PRE-HEARING STAFF ANALYSIS

Rezoning Petition No. 2008-042

Property Owner:	Coliseum Ground One, Inc, Coliseum Ground Two, Inc.
Petitioner:	Crescent Resources, LLC.
Location:	Approximately 15.06 acres bounded by W. Tyvola Road, Yorkmont Road, and Billy Graham Parkway
Center, Corridor, or Wedge:	Center
Request:	O-15 (CD) office conditional to O-2 (CD) office conditional district

RZ1.0

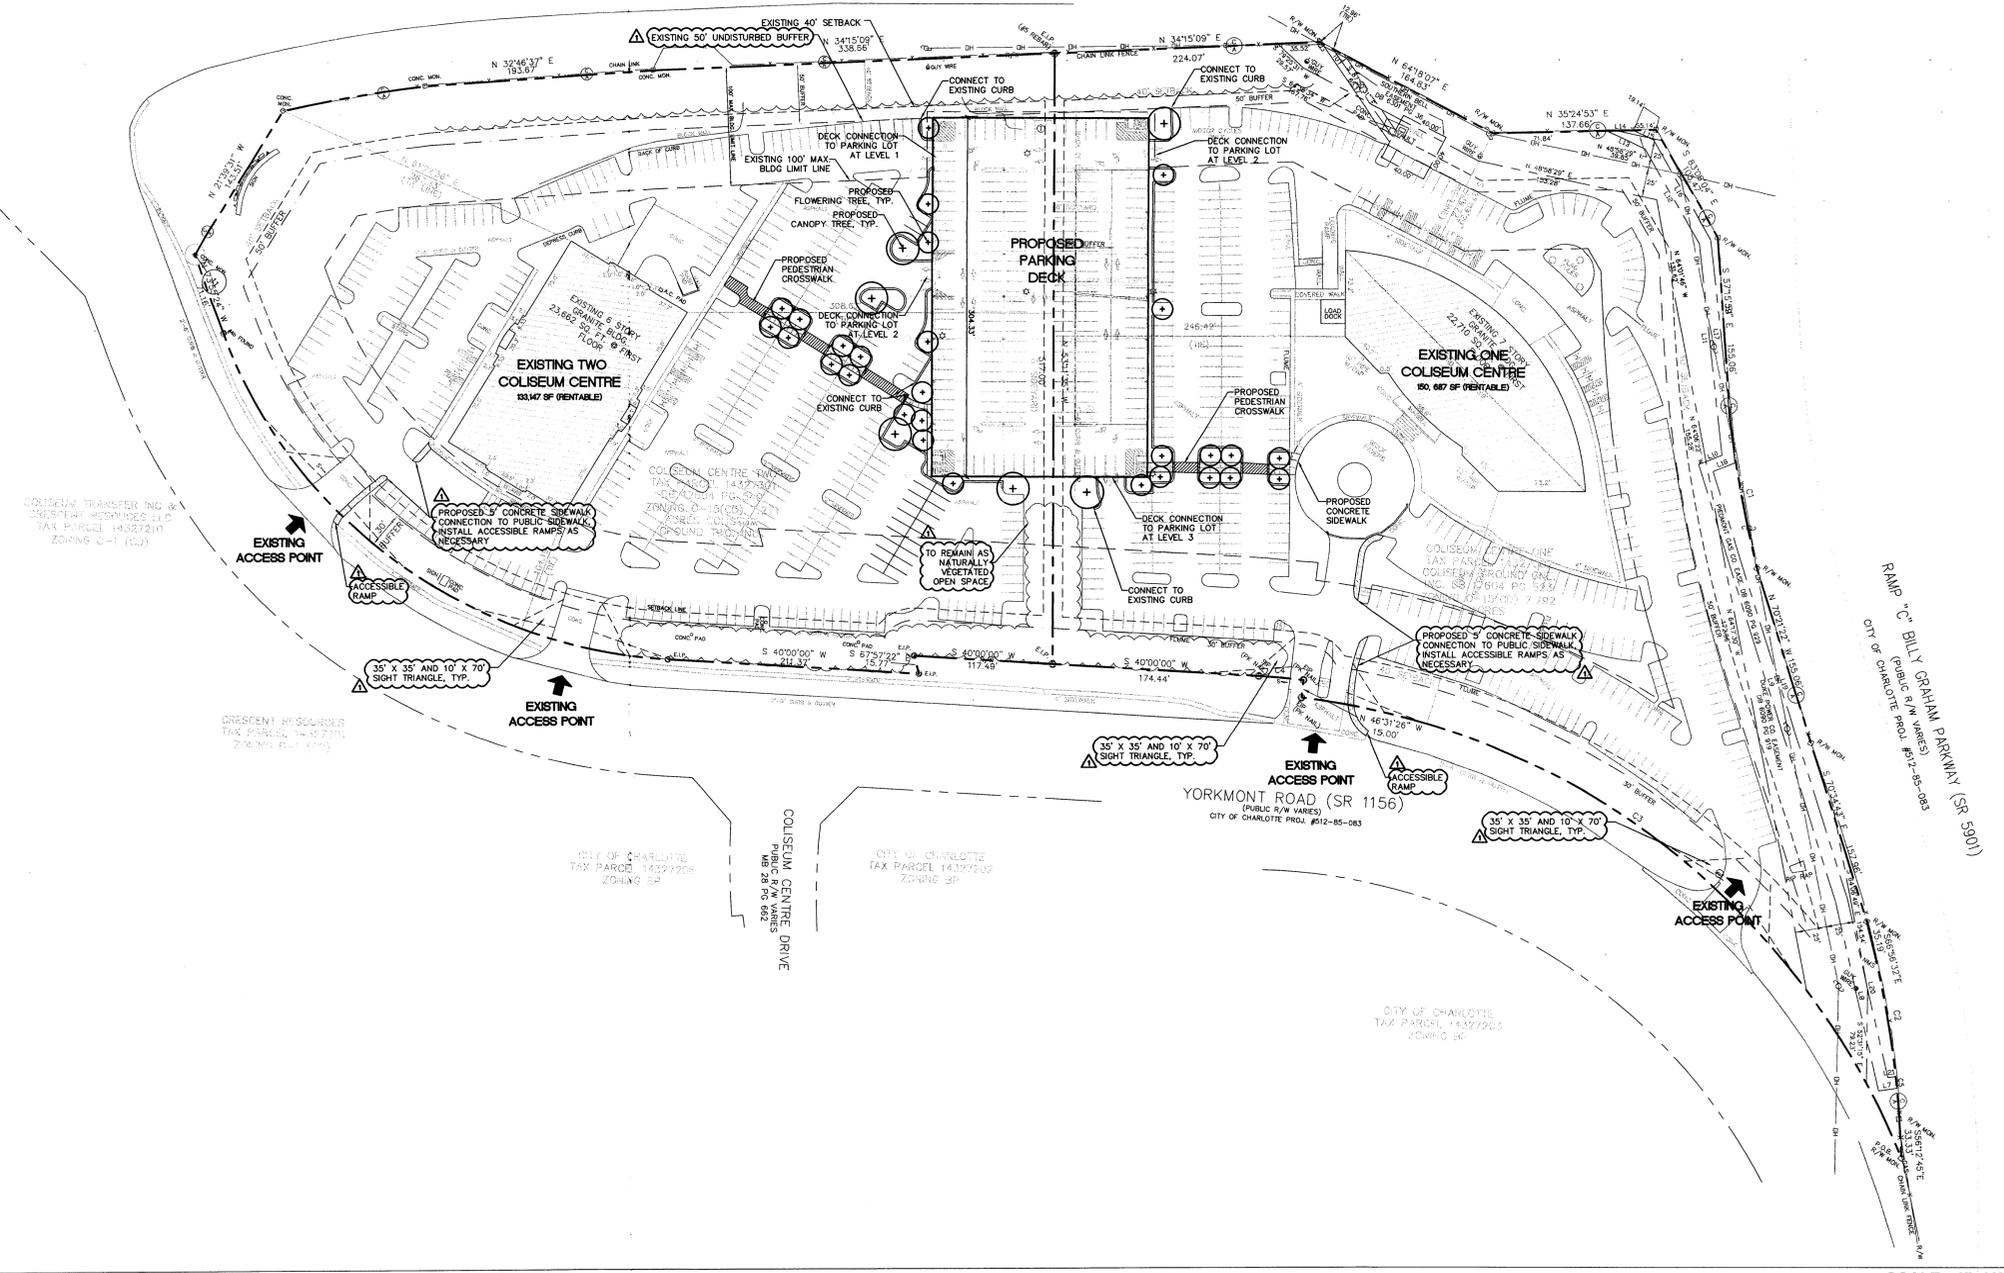
- The petitioner notes that the maximum floor area devoted to office and ancillary uses will be reduced to 310,000 square feet with the structured parking area not included in that total. However the site plan shows two existing buildings with 283,834 square feet. The site plan should show the location of the remaining 26,166 square feet.
- The Petitioner has indicated that the revised site plan will show two alternate locations for the parking deck. Staff reserves the right to comment on this change to the plan once it is submitted.

RZ1.0

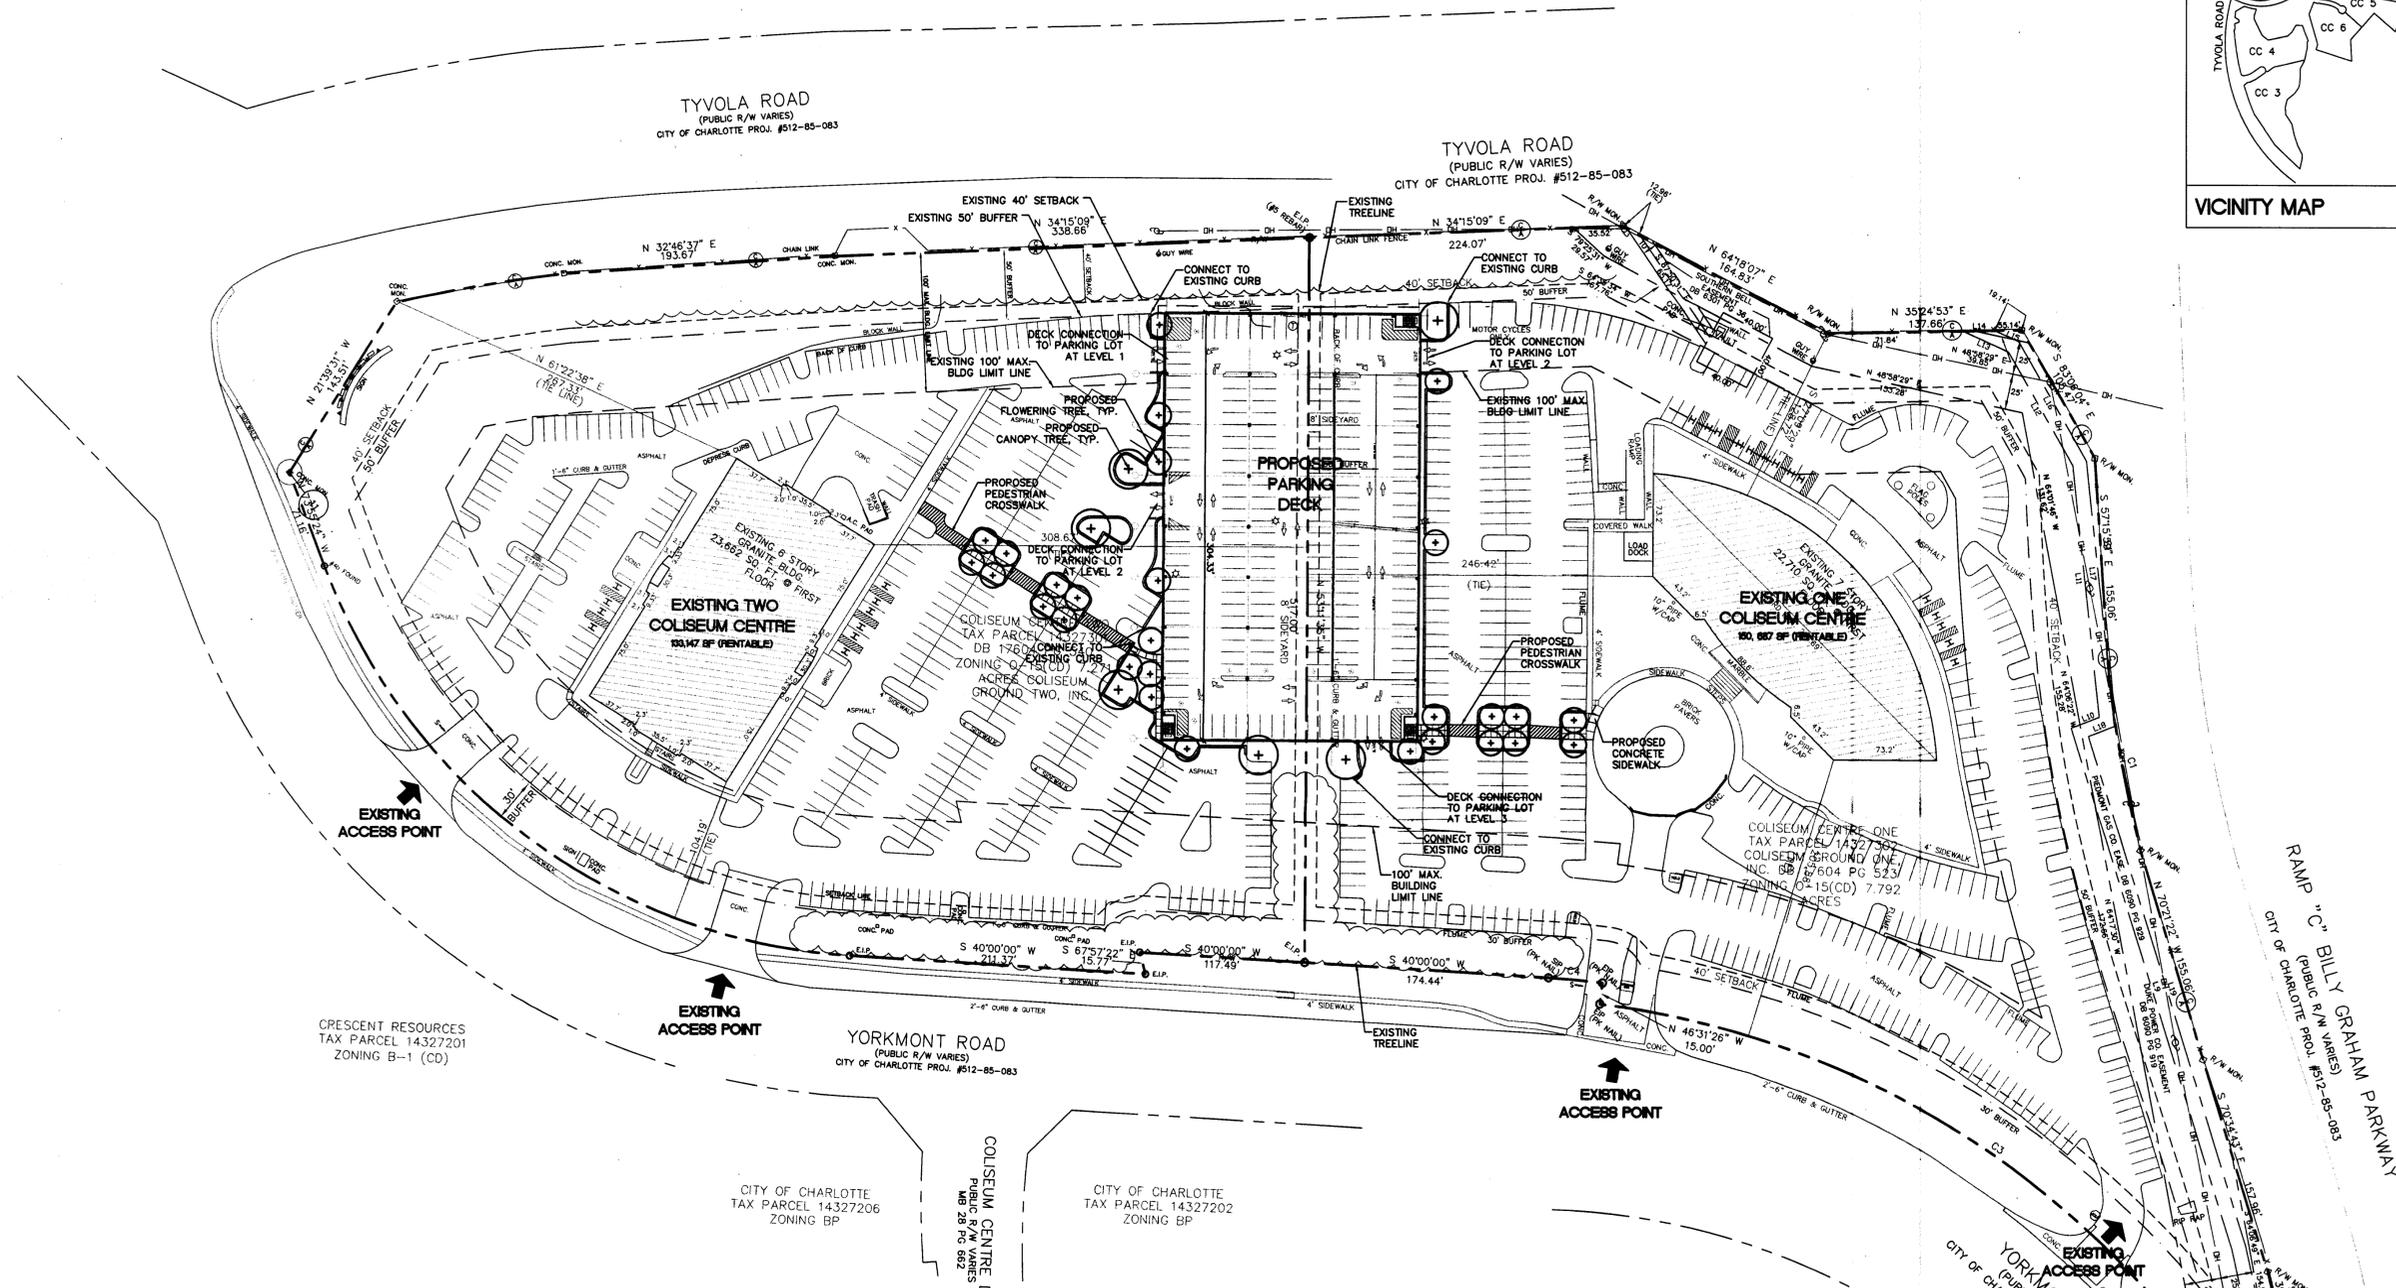
- The site plan needs to provide an internal system of 5-foot or wider sidewalks that connect building entrances to sidewalks along Yorkmont Road and the existing sidewalk on Yorkmont Road needs to be extended to the Billy Graham Parkway controlled access fence.

- The NCDOT State Route or Highway number needs to be labeled for each Billy Graham Parkway and for Yorkmont Road.

- The uses should be limited to office uses – not all uses allowed in the O-2 district.
- The parking deck elevations should be shown as a part of the site plan.
- The 50-foot buffer along Tyvola Road should be labeled as undisturbed.
- The site plan should indicate if the existing trees to the south of the proposed parking deck and between parking rows are to remain.
- A note should be added that the petitioner reserves the right to establish a parking ratio that is less than 5.13 spaces per 1000 square feet provided that zoning regulations are met.
- Under note 1(b) the last portion of the last sentence (“and areas devoted to uses and structures accessory to the uses on the Site”) should be removed. Accessory structures are counted as part of the gross floor area.
- Sidewalk connections should be provided from each building to the existing sidewalk along Yorkmont Road.
